Reference No: **2025/NM/93415/W**

Site Address: land at, Mount Pleasant, Plains Lane, Marsden,  
Huddersfield, HD7 6AN

**DECISION – NON MATERIAL AMENDMENT REFUSED**

## **Officer Report – 2025/93415**

INDICATIVE CROSS SECTION 1:50 @ A1

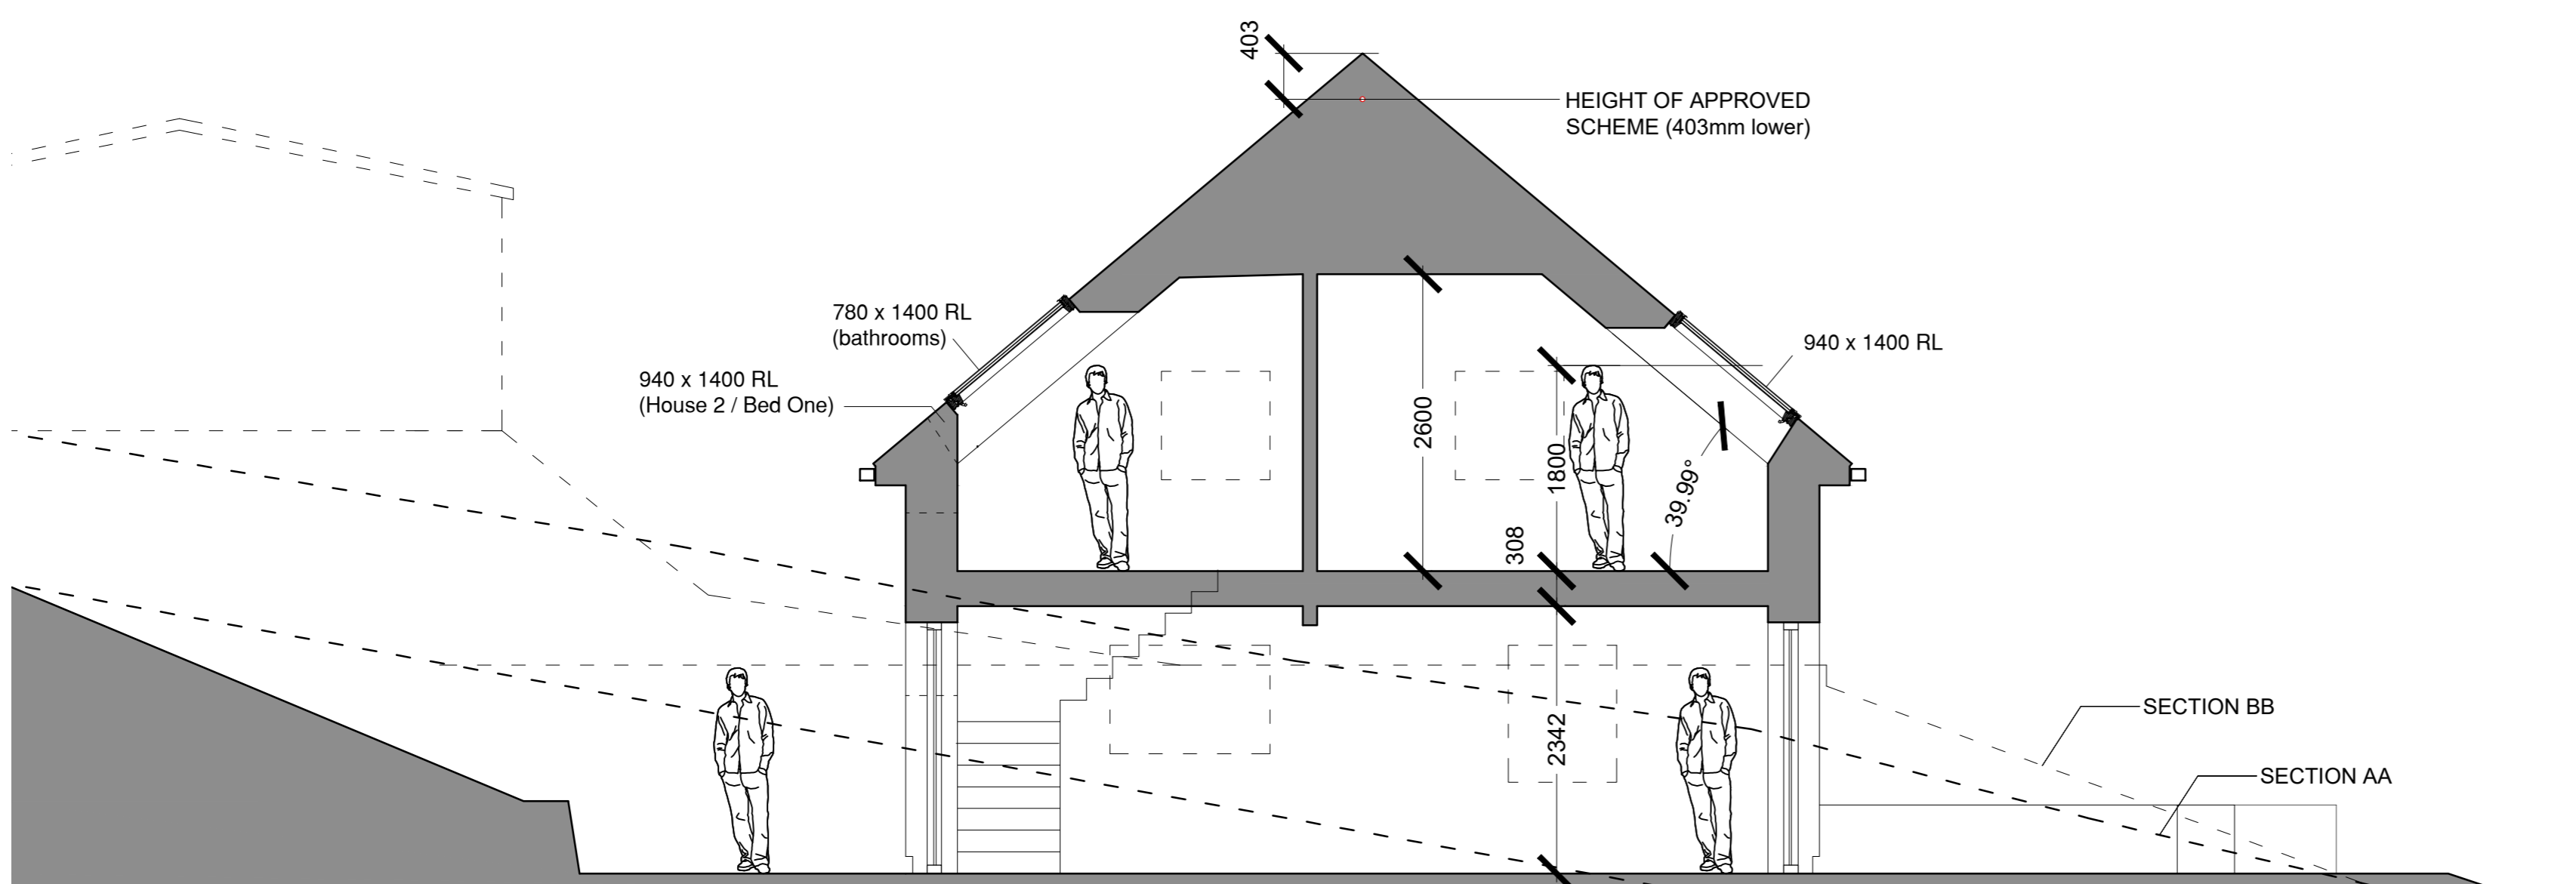
In this instance, the submitted amendments include alterations to window and door positions, the introduction of large rooflights, and the creation of additional habitable accommodation within the dwellings. In addition, the proposal seeks to increase the ridge height by approximately 403mm compared with the approved scheme.

These changes directly align with the categories of development identified within the Council's protocol as being unlikely to be accepted as non-material amendments, namely a material increase in the height of the building. Furthermore, the internal reconfiguration resulting in additional bedrooms (House 1 and House 3) materially alters the functional form and typology of the approved dwellings and the scheme would require assessment of the impact in terms of the amenity of future occupiers.

Whilst the proposed alterations to external openings, roof detailing and larger roof lights across the roof would be acceptable in isolation, in terms of visual and neighbouring amenity impacts. The overall quantum of the development is considered to fall outside the scope of that which can be considered a non material amendment in this case.

Accordingly, the proposal falls outside the scope of what can reasonably be regarded as non-material within the meaning of Section 96A of the Town and Country Planning Act 1990.

The amendments shown on drawing No 37/2405/10 are not considered appropriate to be regarded as a non-material amendment to the previous planning approval (reference 2024/93046).
